**From:** George Smith  
**Sent:** 22 March 2021 11:16  
**To:** DC Support  
**Subject:** FW: Planning notification for application reference: 21/00477/F  
**Attachments:** eCon\_(1).pdf

I am commenting on the above application from an arboricultural aspect.

PROPOSED BARN

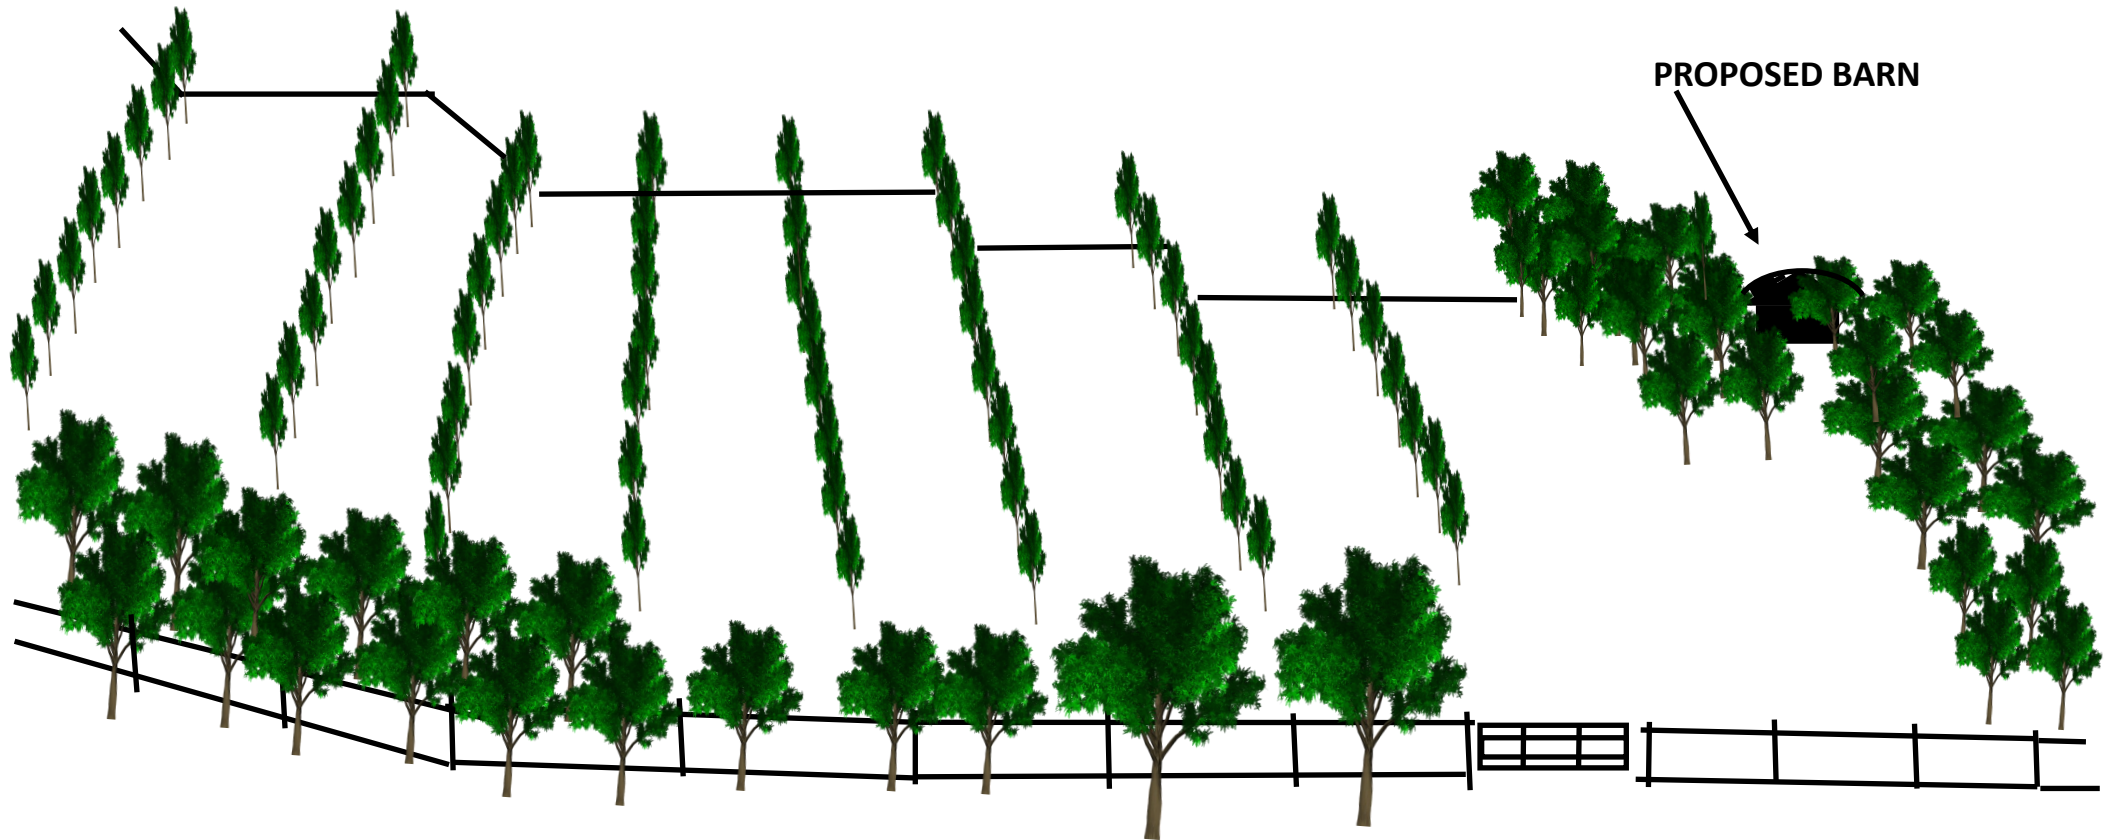
I have studied the plans and note that the proposed barn is in an area covered in trees. I understand there has been a recent issue with unauthorised tree removals but under the current aerial view an arboricultural impact assessment is required in line with BS5837(2012), which should be submitted by an approved arboricultural consultancy.
